**Subject:** Minor Exterior Amendments

**Reference:** Starbucks Renovation  
8101 San Petro Drive NE  
Albuquerque, New Mexico

2 EXTERIOR ELEVATION - NORTHEAST

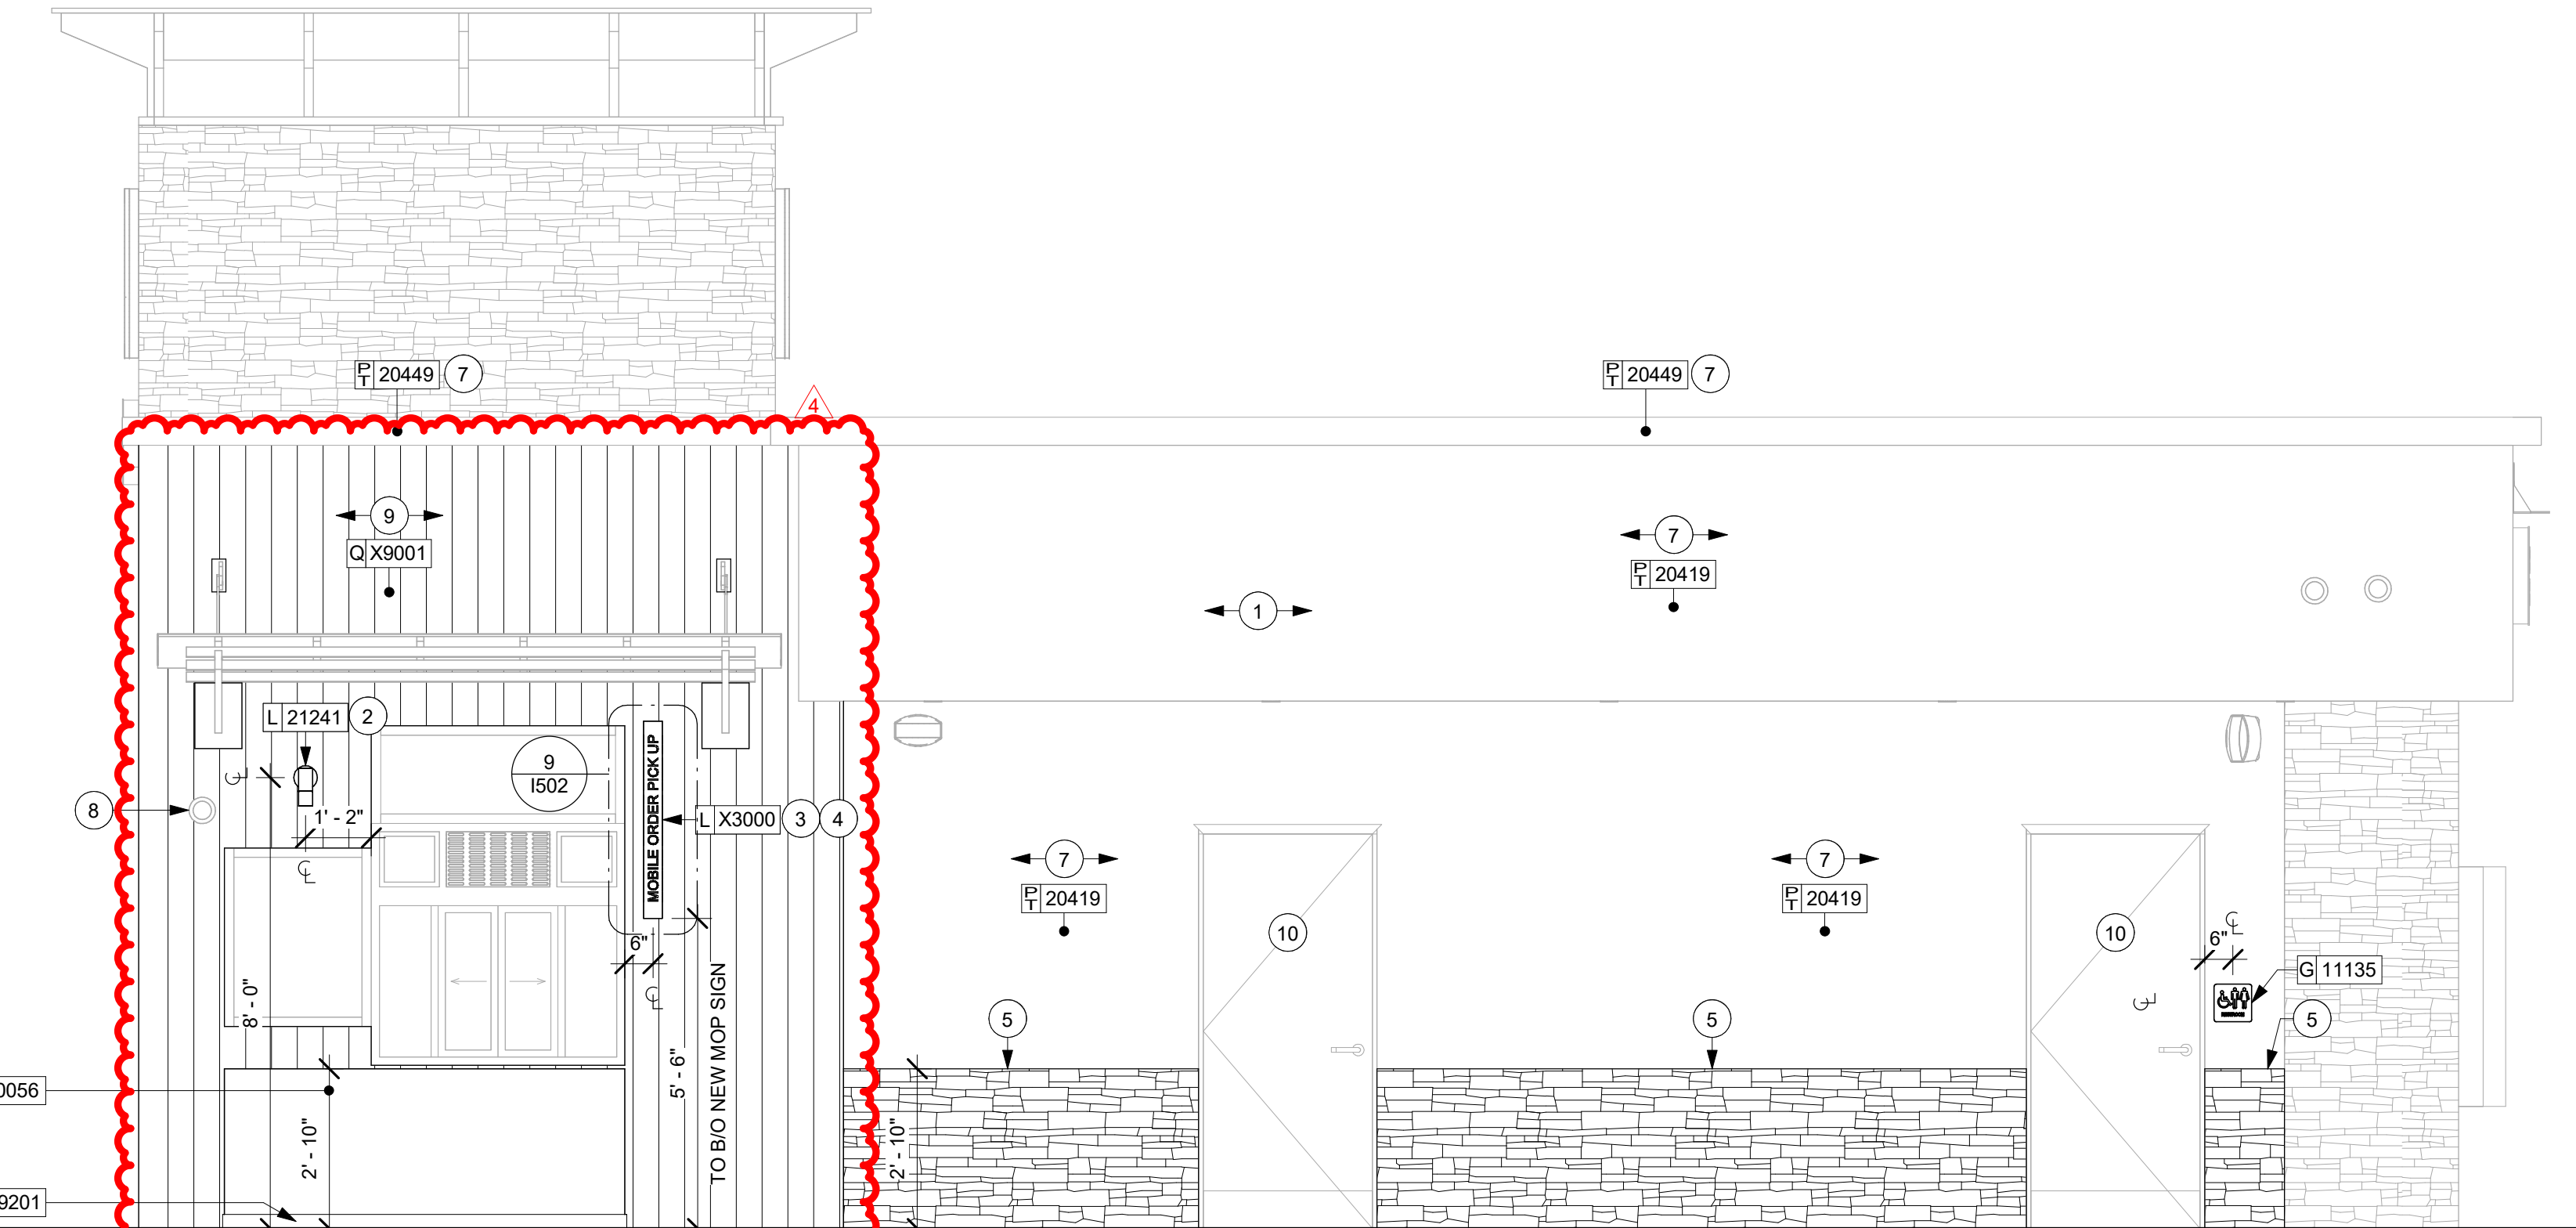
- the elimination of an existing trellis,
- the introduction of upgraded exterior materials at both the northeast & northwest exterior elevations of the façade. The exterior elevations will feature a new enhanced wood finishes (NewTechWood All-Weather Planks) and an increase in the amount façade stonework.
